Office of Water

17 August 2010

RASP PROJECT – MP07_0018 – EXHIBITION OF ENVIRONMENTAL ASSESSMENT

Specific Comments – Water Resources and Water Licensing

Figure 10-2 Conceptual hydrogeological model of the Broken Hill domain (source – Caritat et al., 2002)

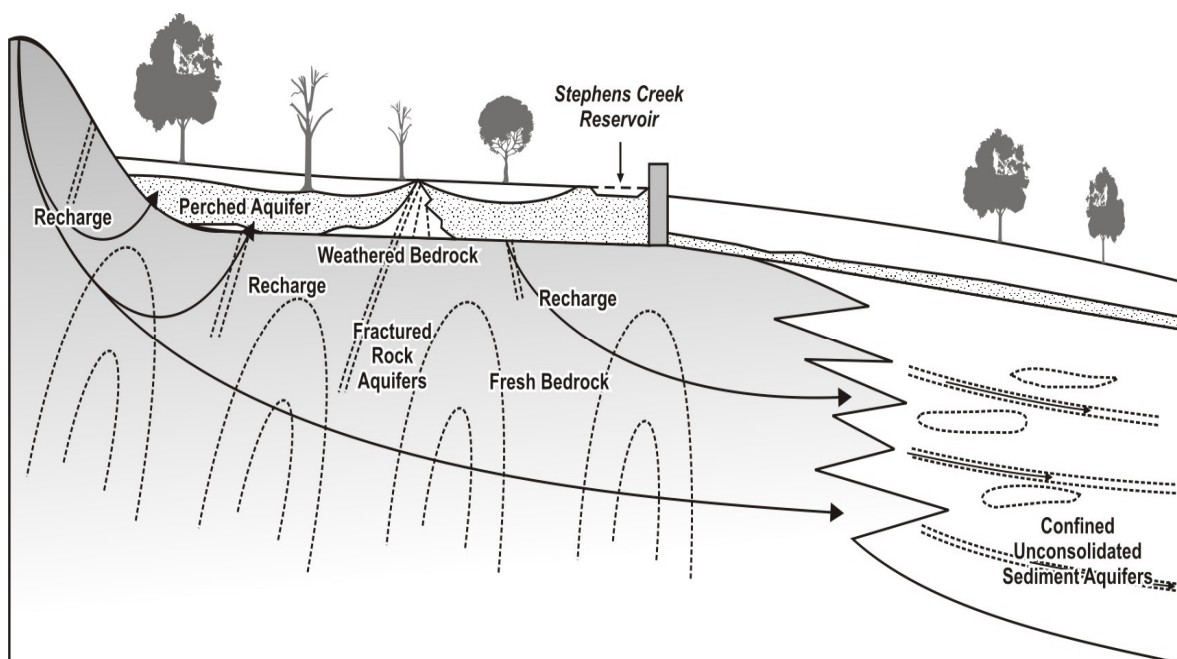
- The seepage rates anticipated within the tailing storage facility (TSF) and the underlying material are based on estimated permeability factors and observations rather than measured factors. There are also considerable assumptions in regard to the composition and structure of the existing tailing storage facility. NOW therefore considers there is a significant level of uncertainty in the predicted seepage patterns within the existing TSF and therefore the potential for mounding beneath the TSF and lateral seepage movement. A comprehensive monitoring program of toe drain function, groundwater mounding and seepage points is critical to understand and enable effective management of this issue.

- The proponent must prepare a Groundwater Management Plan to monitor seepage movement within and adjacent to the Tailings Storage Facility in consultation with and to the satisfaction of the NSW Office of Water prior to commencement of activities.

Figure 10-3 Location of boreholes within the region

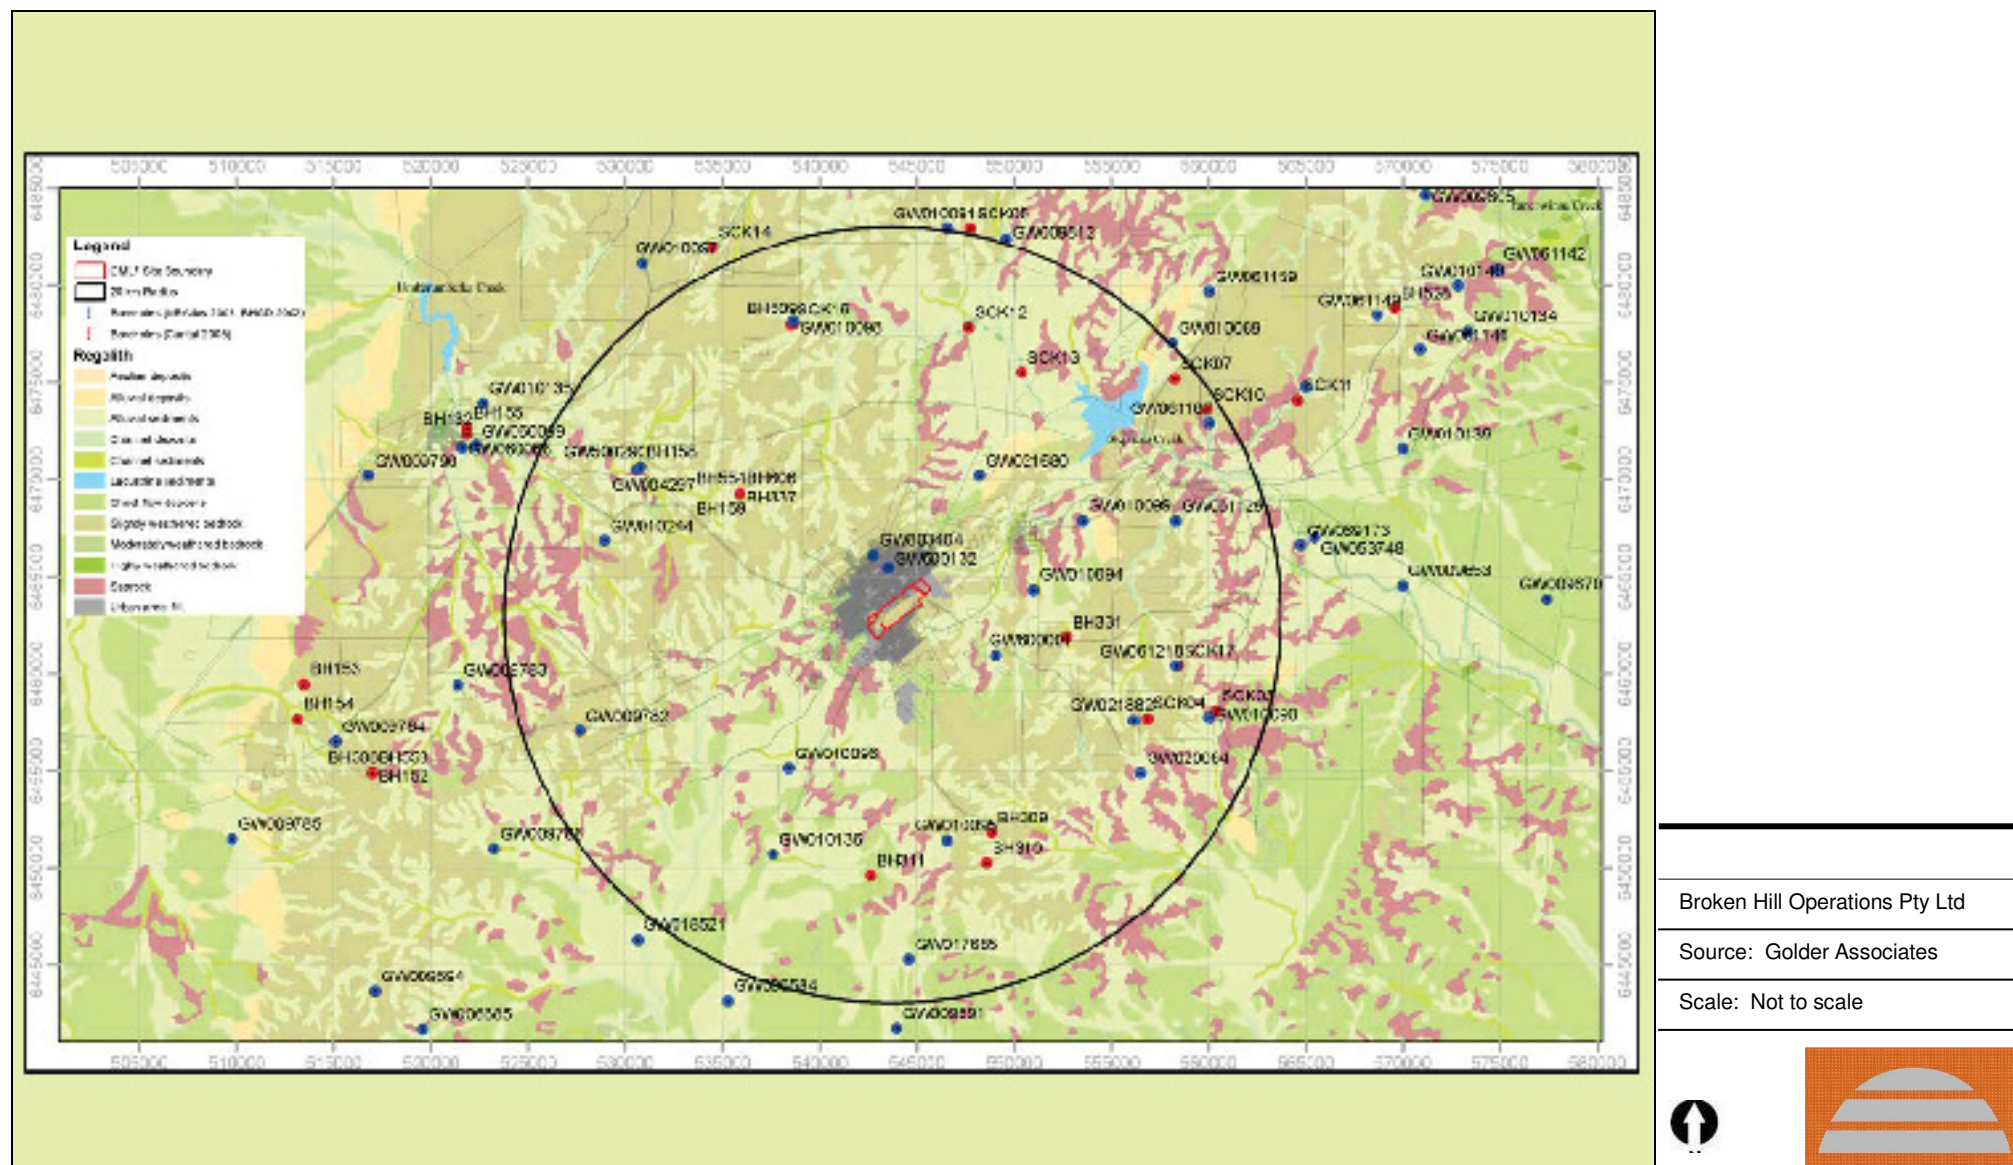
- The dewatering requirements of the proposed deepening at the site have been estimated based on existing pumping requirements at Shaft No.7 with no use of modelling based on site specific parameters. There is therefore considerable uncertainty in the applicability and associated accuracy of these figures. The proponent will be required to ensure appropriate licensing under the *Water Act 1912* is obtained for all groundwater interception and/or extraction activities for the life of the mine and for post mining life if required.

- The proponent must obtain relevant licenses to the satisfaction of the NSW Office of Water under the *Water Act 1912* for all activities which intercept or extract groundwater prior to commencement of these activities.
